Single storey front extension. This application affects the character & appearance of
Aldwick Bay Conservation Area.

16 The Fairway Aldwick

Thank you for your internet representation made on 4th February 2020 which has been
recorded as '**no objection**' with the comments as follows:

PROPOSED ELEVATIONS

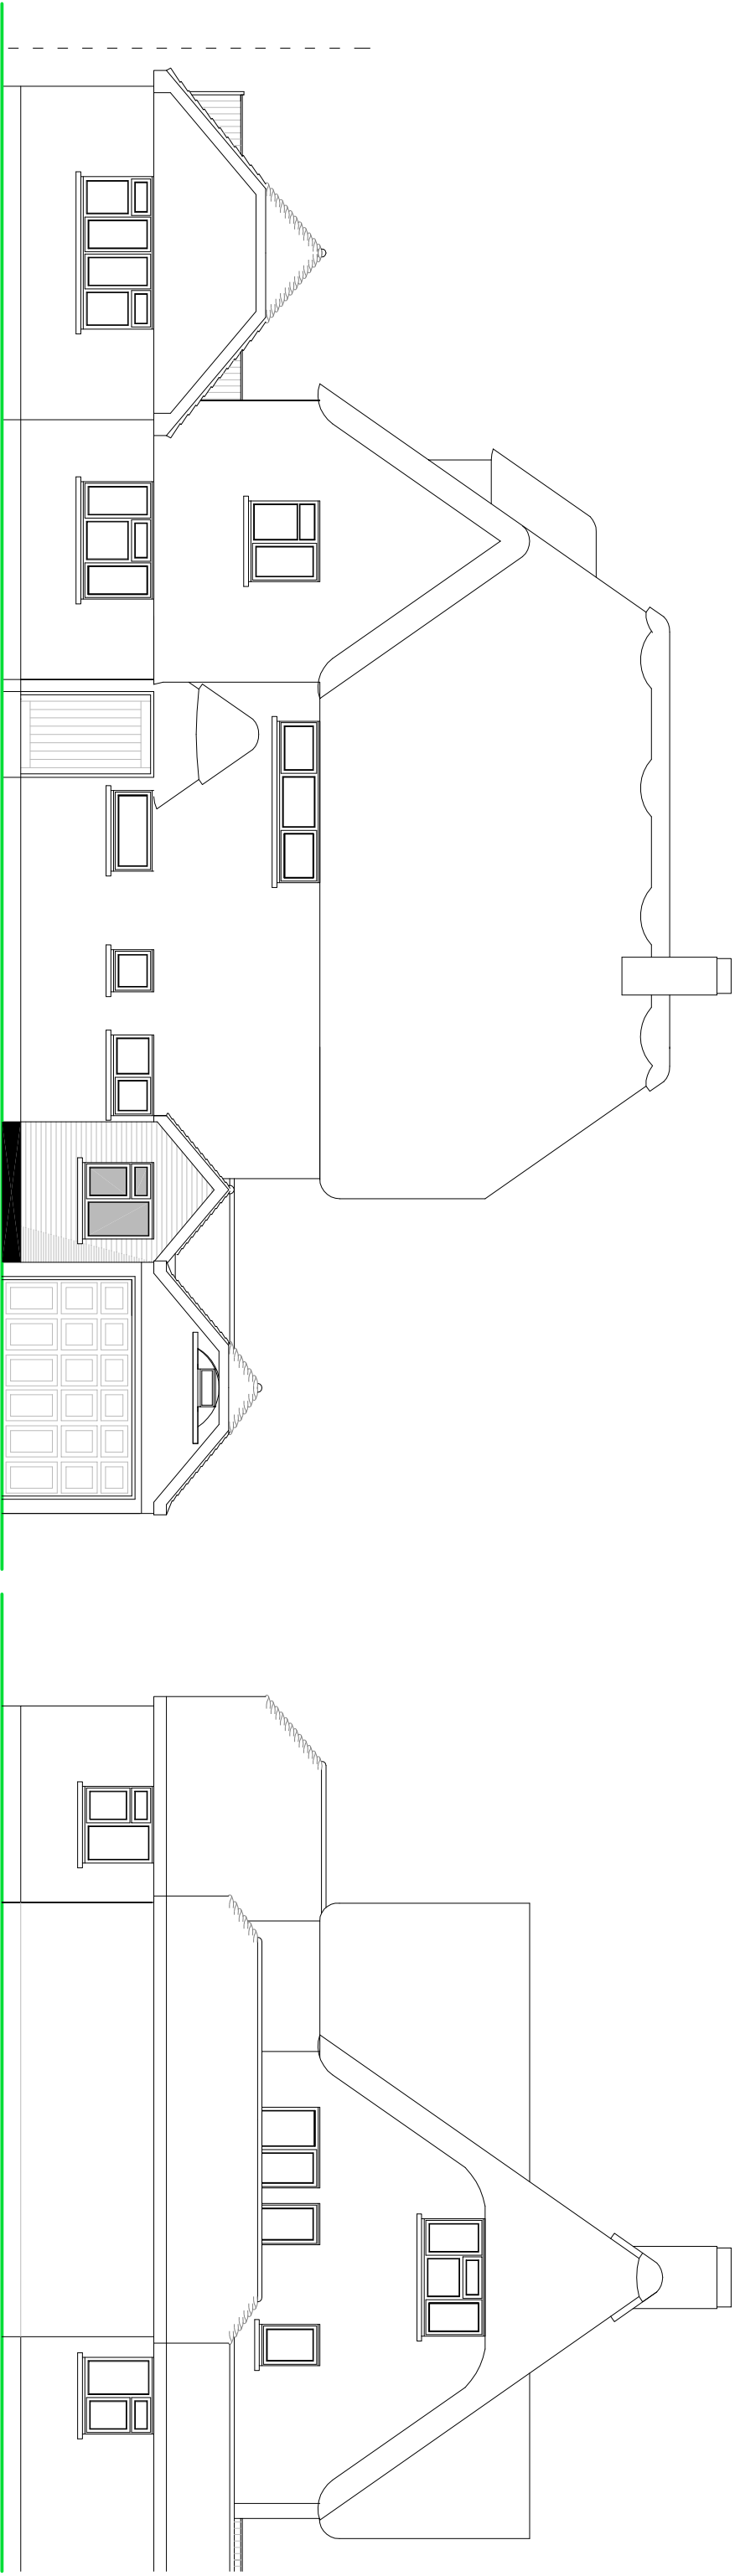
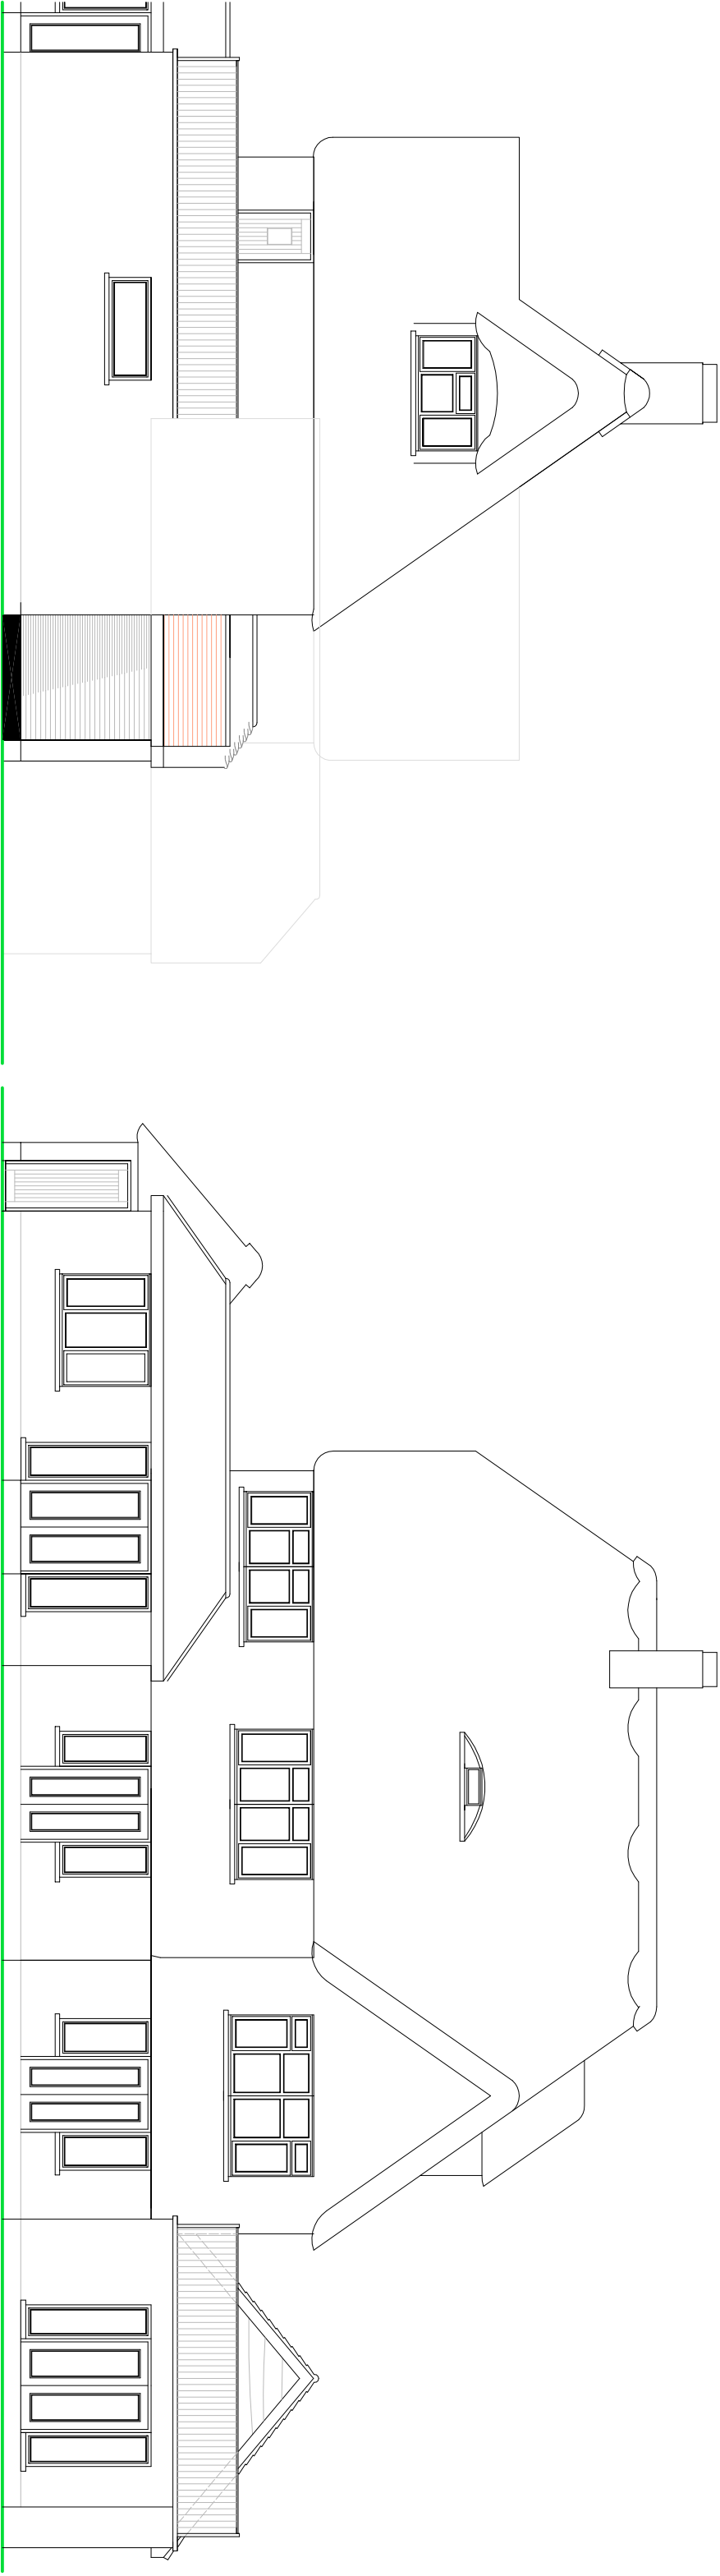
*The Panel would prefer to see the use of simple casement windows without the top hung
light. The detailing of the barge board also needs care. Materials should match the
original building and be of good quality.*
